Permitting and Inspections Department
Michael A. Russell, MS, Director

01/31/2018

Re: Permit # 2017-00115

SHEET: S1.4

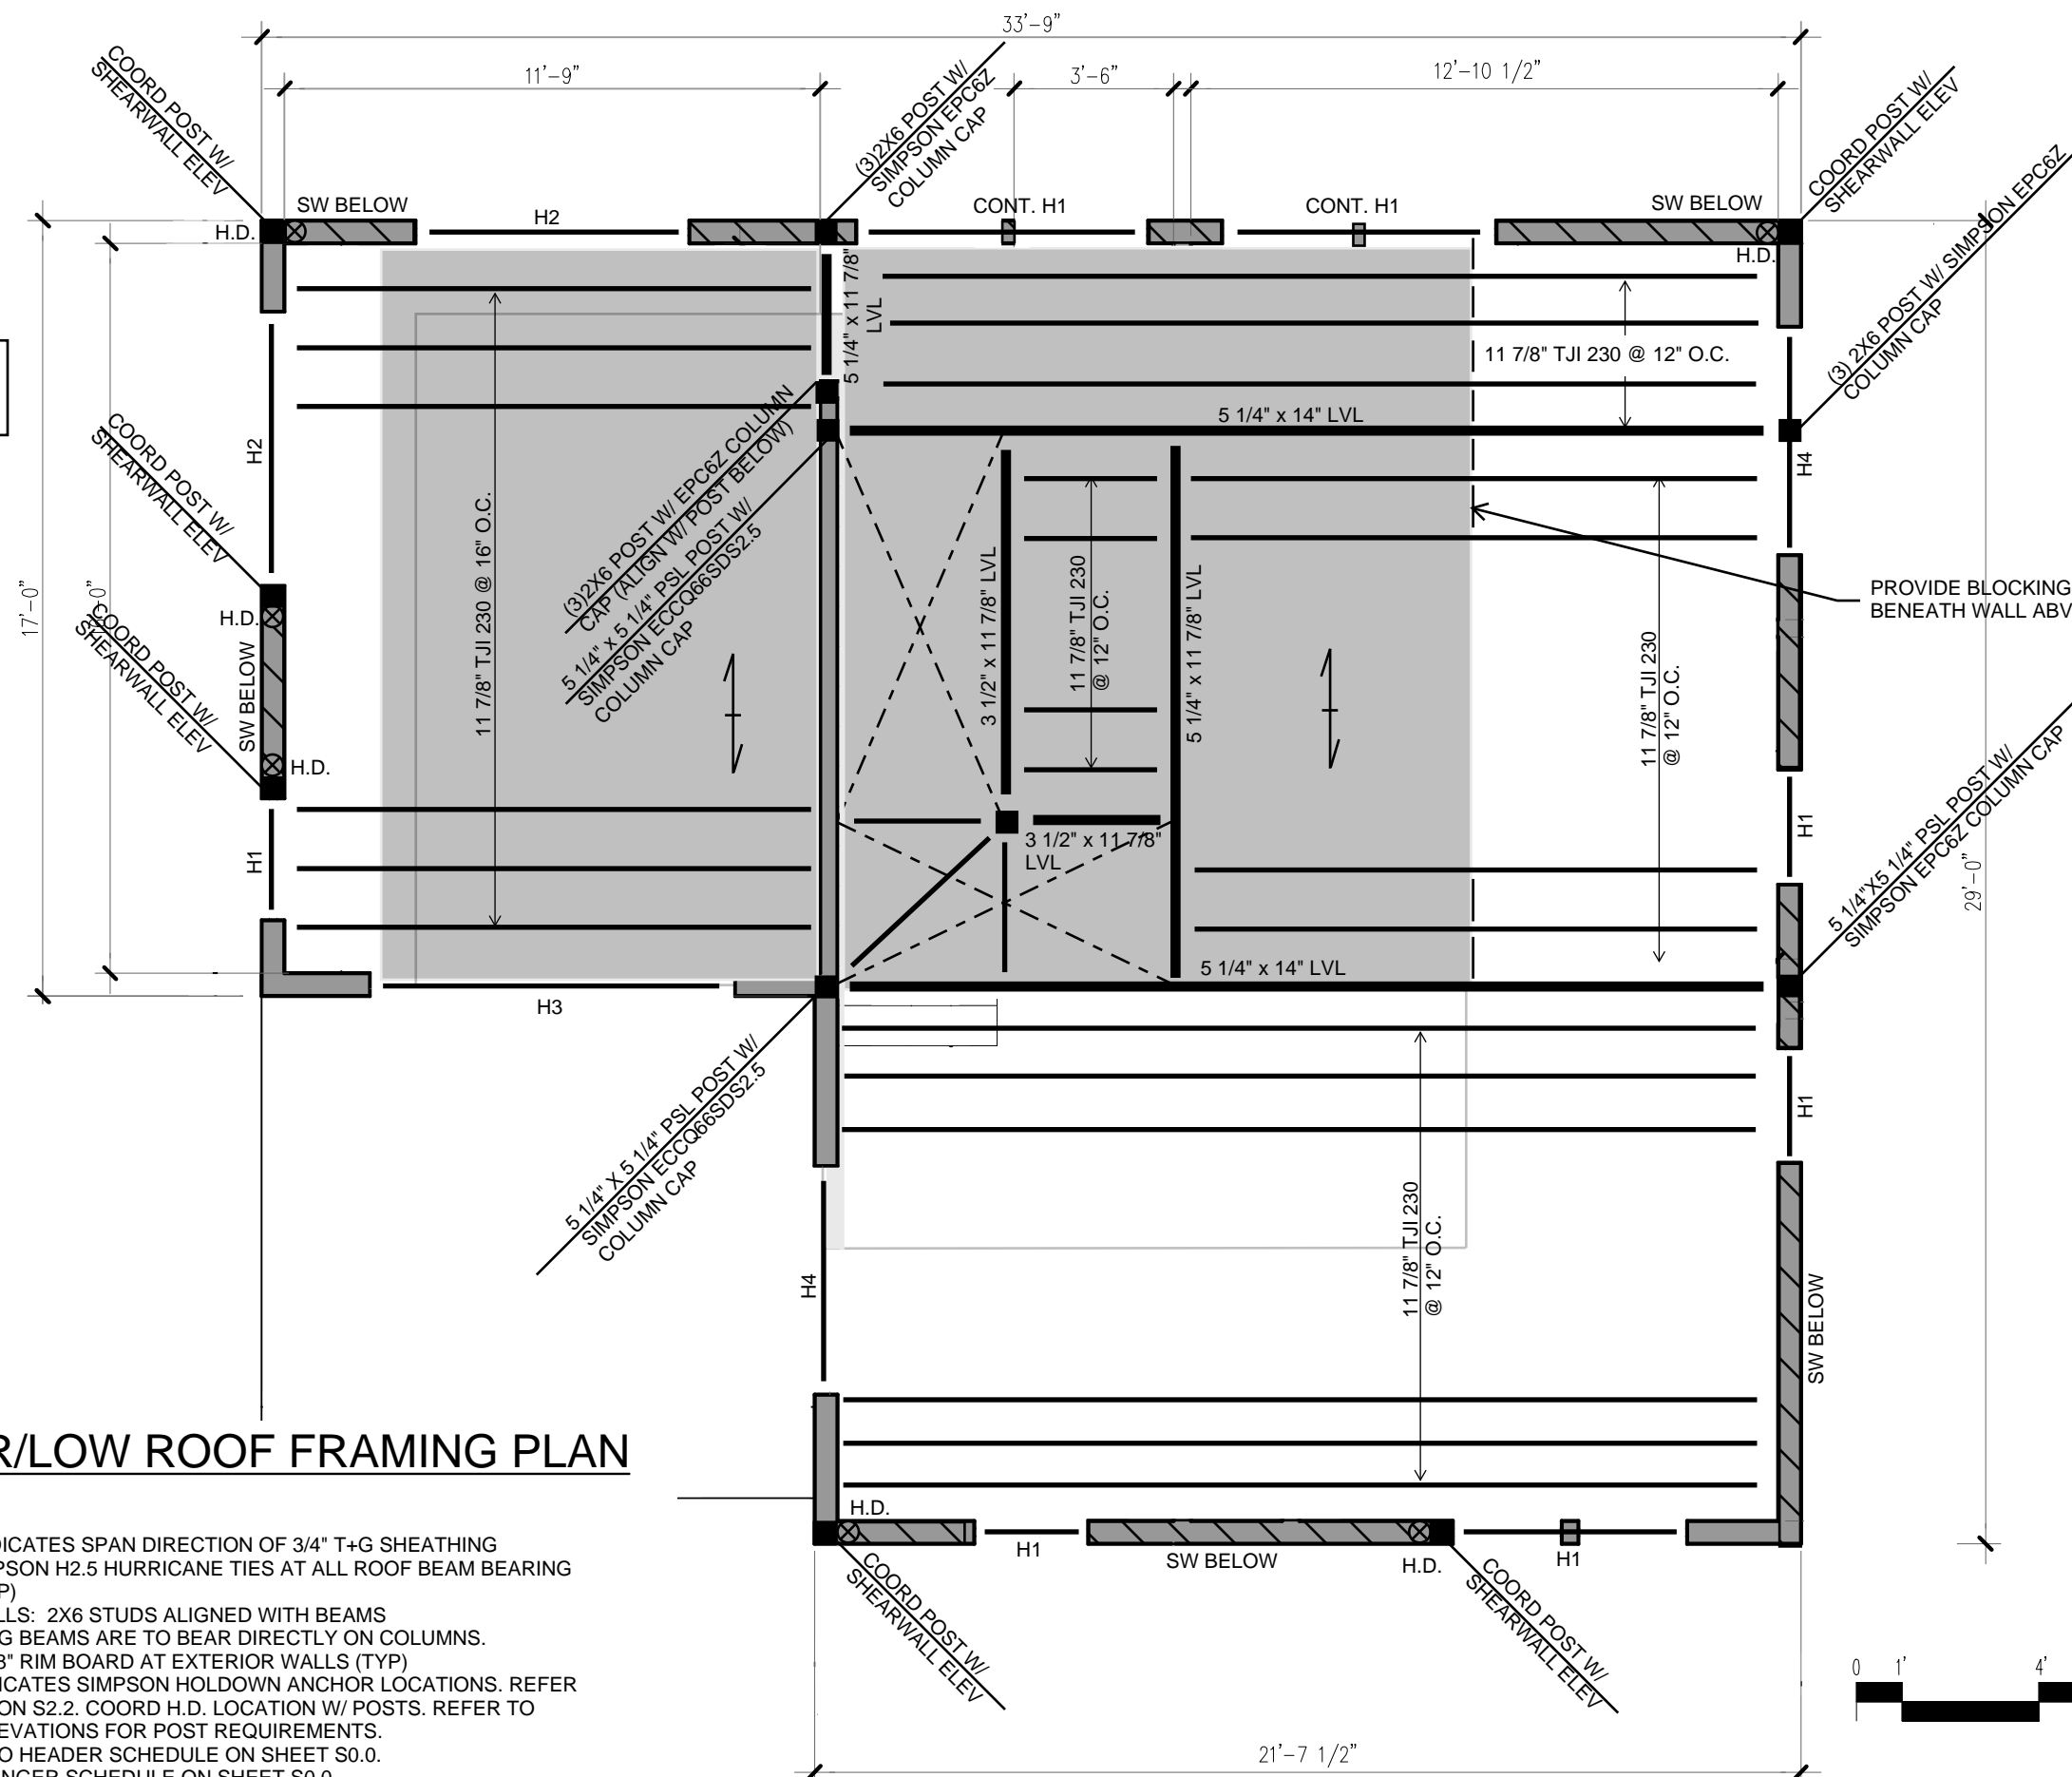
As discussed during your phone conversation with Doug Morin, Code Enforcement Team Leader, the fourth floor of the structure at 34 Howard Street does not meet the rear setback requirements in the City's Land Use Code, and will need to be moved or reduced in size. The zoning review for this property specifically noted the setback requirements for the fourth floor, given its height, and it appears that your architects understood these requirements when they designed the building. I understand your concern regarding the design review feedback, however, the design review standards do not excuse compliance with the dimensional zoning standard.

The City is willing to allow work to continue on this project, so long as we are able to work towards an acceptable plan to bring the building into compliance. To that end, please submit a plan of correction and revised plans that meet the setback requirements for the fourth floor.
